Noise Peer Review

То:	Jon Novoselac	At:	Umwelt (Australia) Pty Limited
From:	Gustaf Reutersward	At:	SLR Consulting Australia Pty Ltd
Date:	1 November 2021	Ref:	640.30314.00000-M01v.01- 20211101.docx
Subject:	Thunderbolt Energy Hub Noise & Vibration Assessment Peer Review

As requested SLR has reviewed the *Thunderbolt Energy Hub Stage 1 Noise and Vibration Assessment* report dated October 2021 authored by Sonus, ref: S6576.1C2, (the Sonus Report) and I can make the following recommendations for amendment.

Figure 1: 35 dB(A) Noise contour with WTGs and nearby dwellings

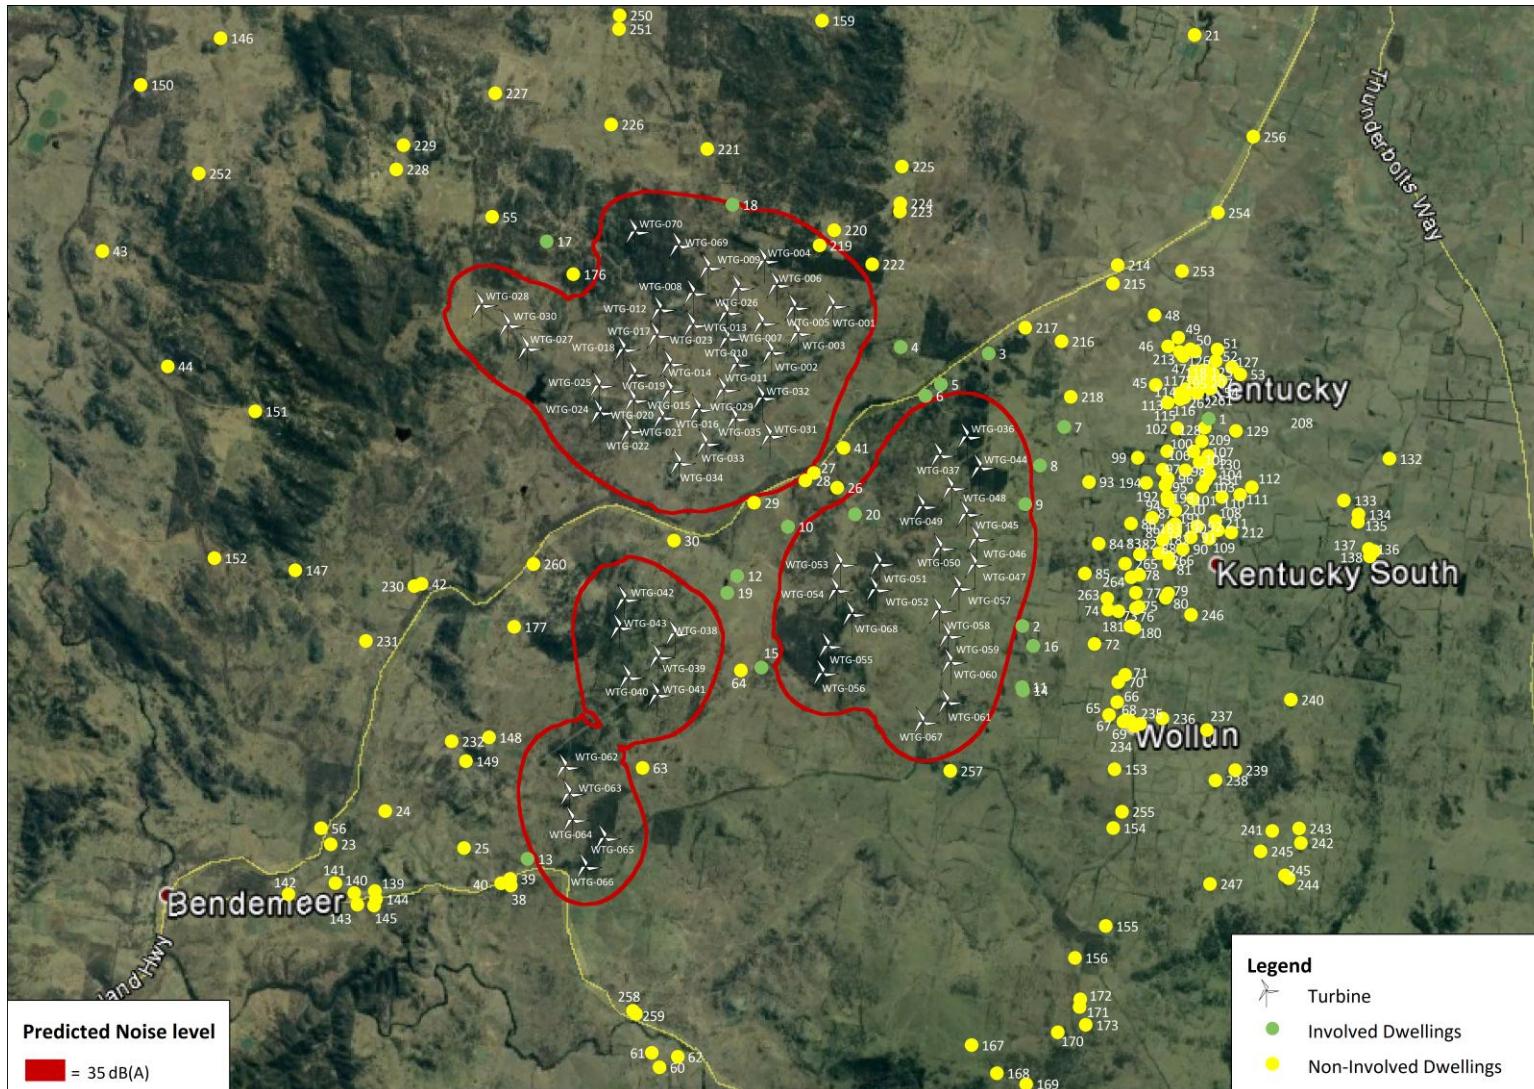
• Appendix D - Noise Prediction Contours - Whilst 35 dBA represents the minimum criteria, it would be useful to see more than one contour, especially given that not all presented receptors are detailed in the results table.
